Your ref: 3/2018/0036

Date: 1<sup>st</sup> February 2018

**Planning Application 3/2018/0036: Conversion of existing barn to one new dwelling with associated alterations to access incorporating retention of unauthorised new window openings and door, and enlargement of original openings. Manor House, Howgill Lane, Rimington BB7 4EF**

5364 -01

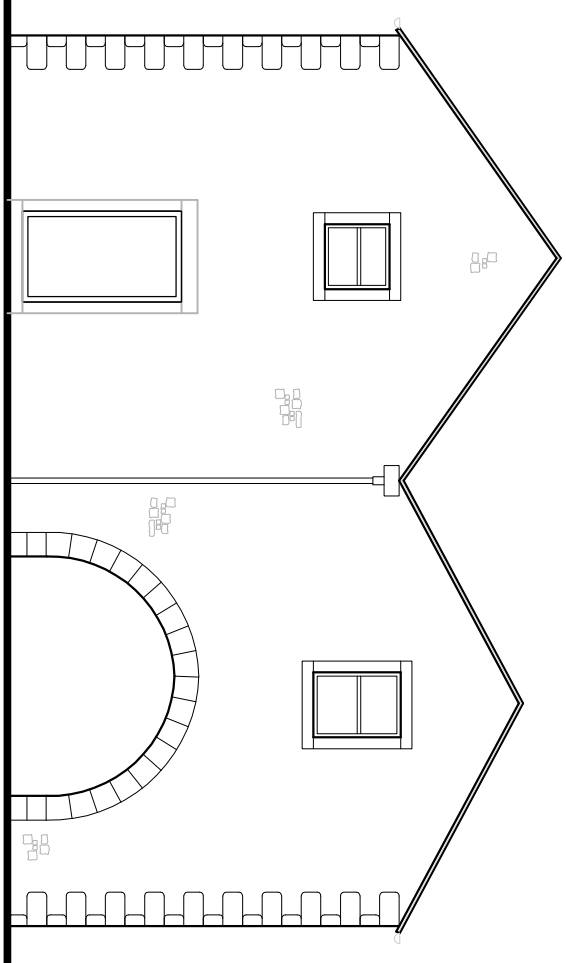
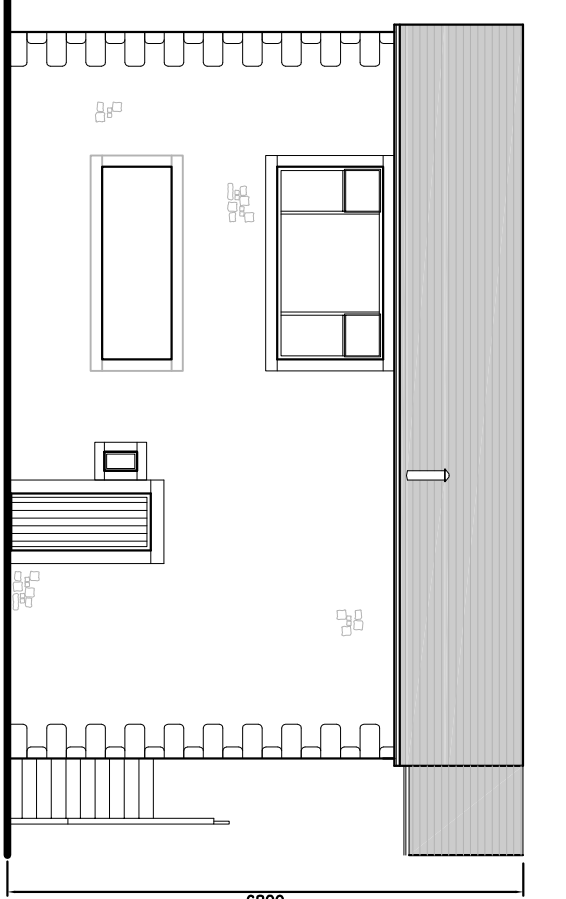
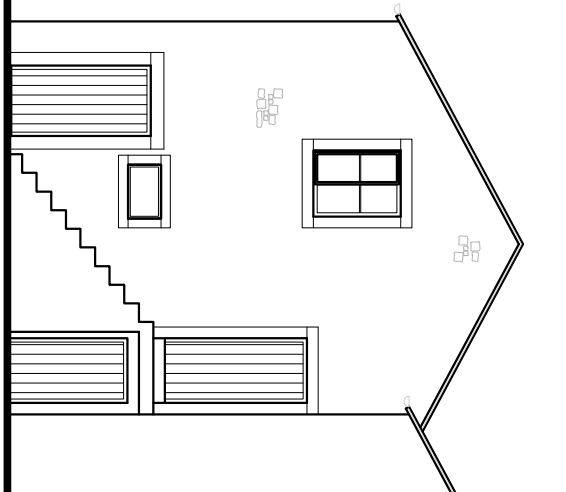
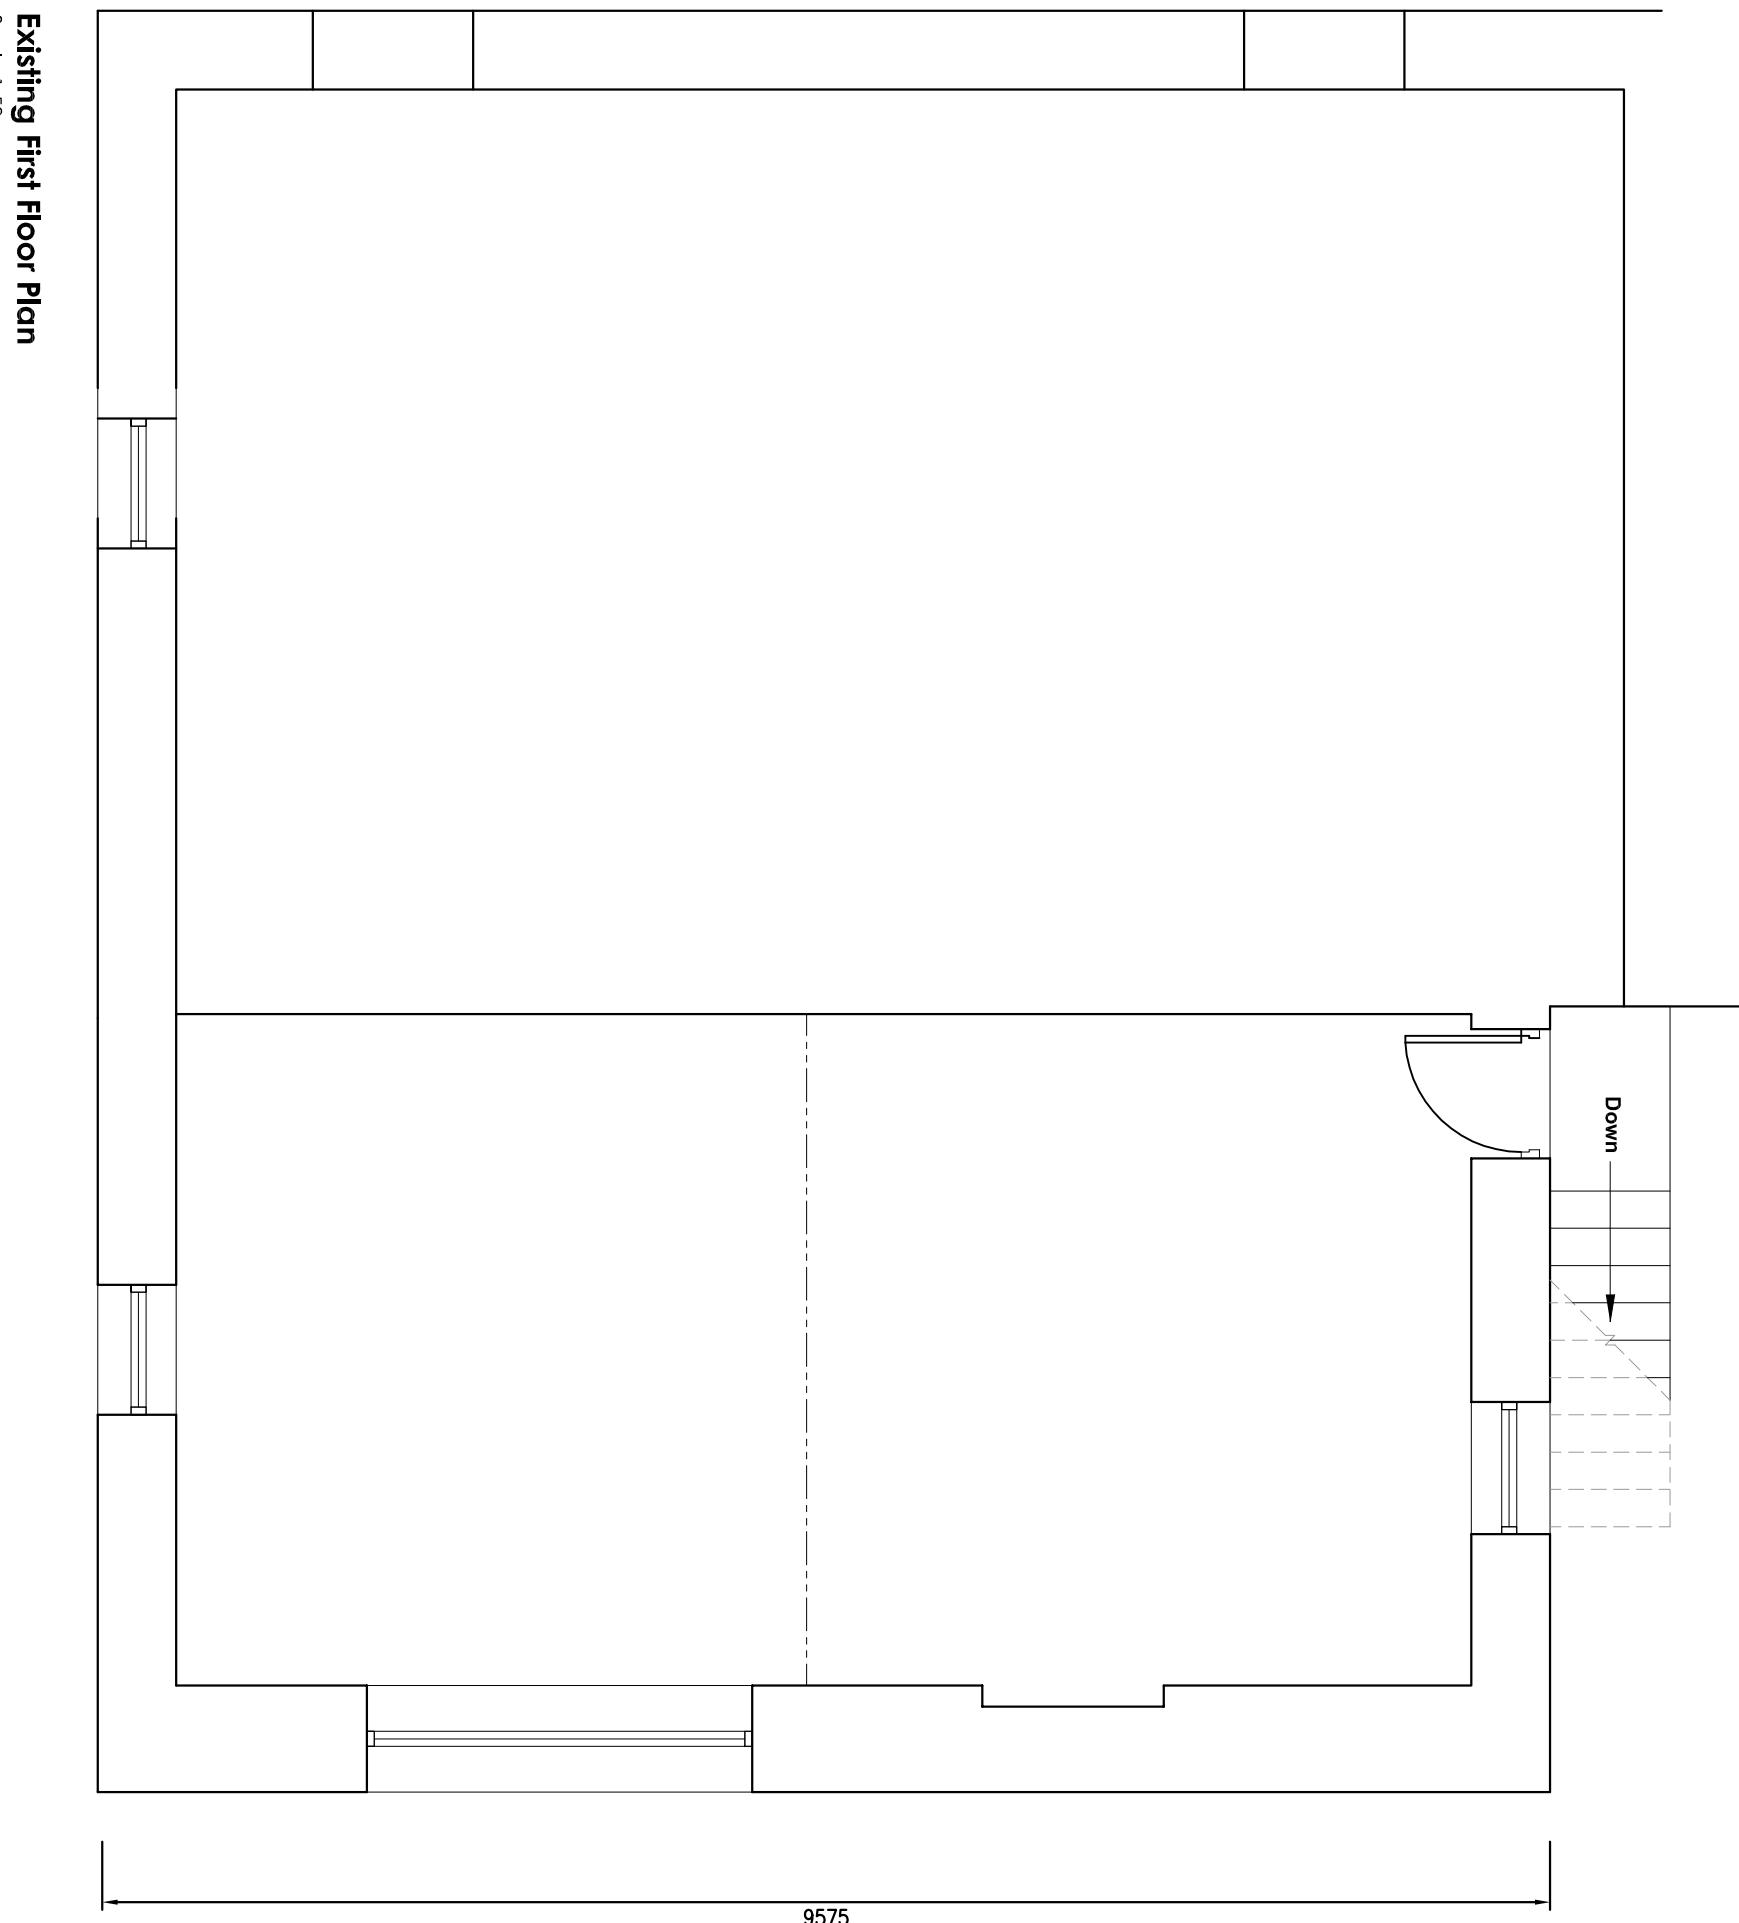
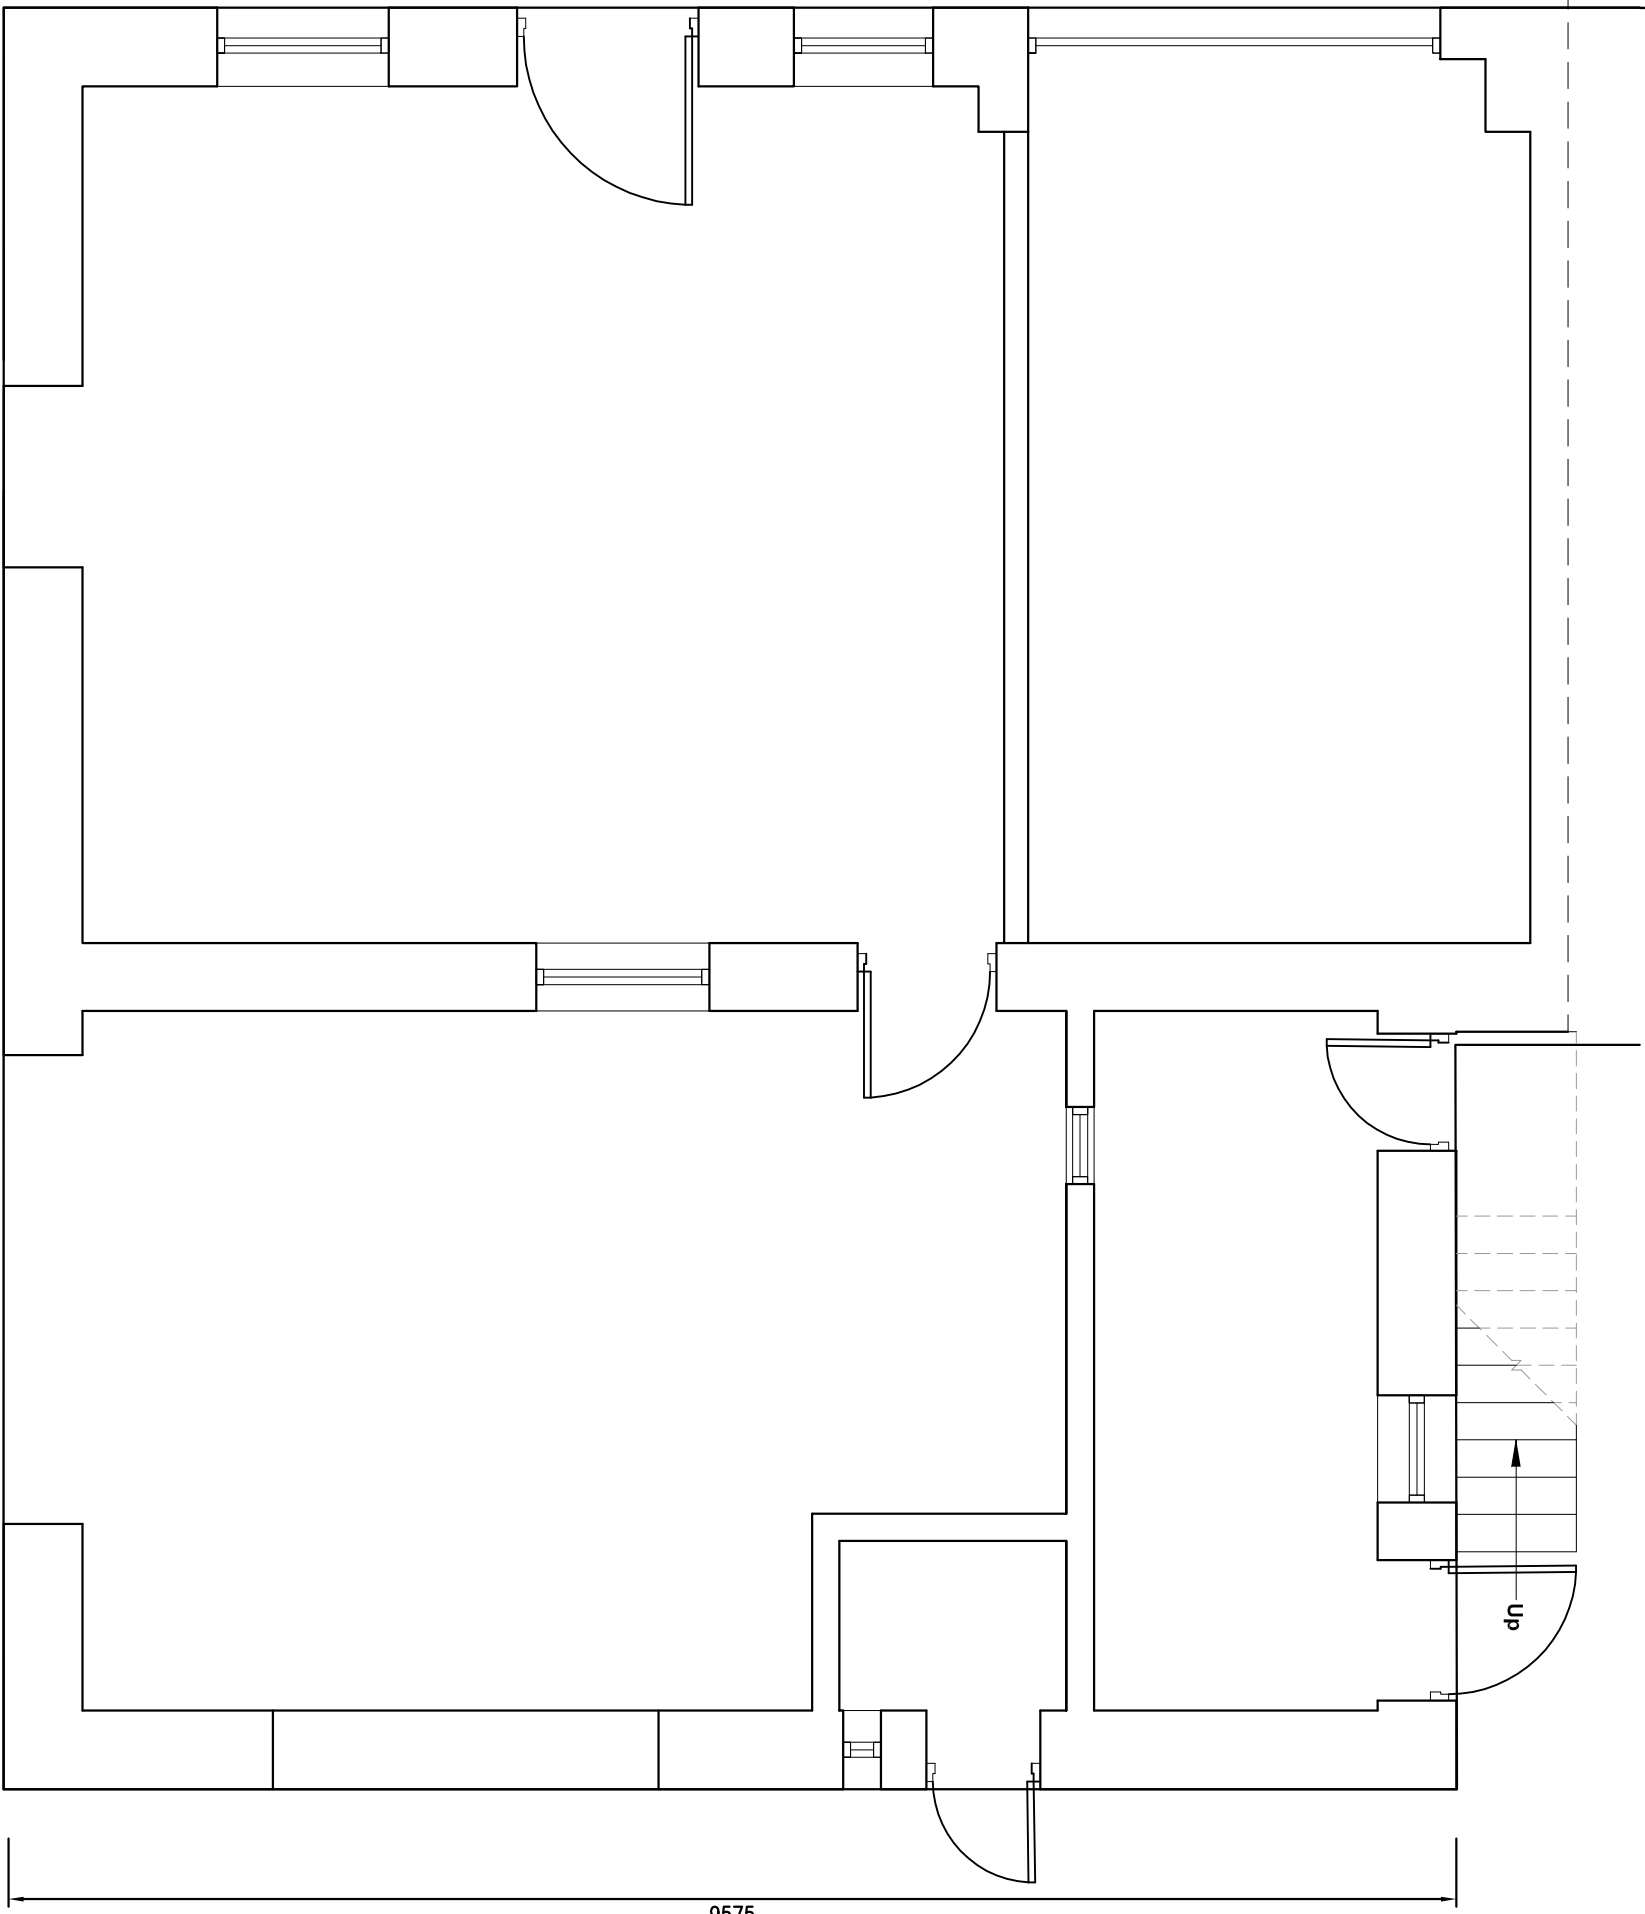
Firstly the description of the proposed works above, taken from the consultation letter, does not match that on the Council's web site nor the wording on the application form. Comparison of the building plans 'as existing' (5364-01) and the photographs of the building contained within the Bat Survey and presumably taken during the reported building inspection of 27<sup>th</sup> March 2017 (BS, p.1) shows a significant number of inconsistencies, not least in the number of doors and windows but also the absence of a dividing wall between the north and south sections of the barn at first floor. It seems likely that the latter is simply a drawing error but the former seem probable to be the 'unauthorised' changes noted above. None of these 'unauthorised' changes are noted on the drawings 'as existing' or 'as proposed' nor is any other evidence provided as to their location, form and extent. As a result it is difficult, if not impossible to come to an informed decision as to their impact on the building.

We would therefore recommend that the applicants are required to submit further information relating to the form of the barn prior to the unauthorised alterations in 2017 and the location and form of those changes, as well as a formal heritage statement describing the significance of the heritage assets here and assessing the impacts of the proposals upon them. This may require field evaluation to assess any buried remains. Without this information, it would not seem possible to provide consent to the current proposals.
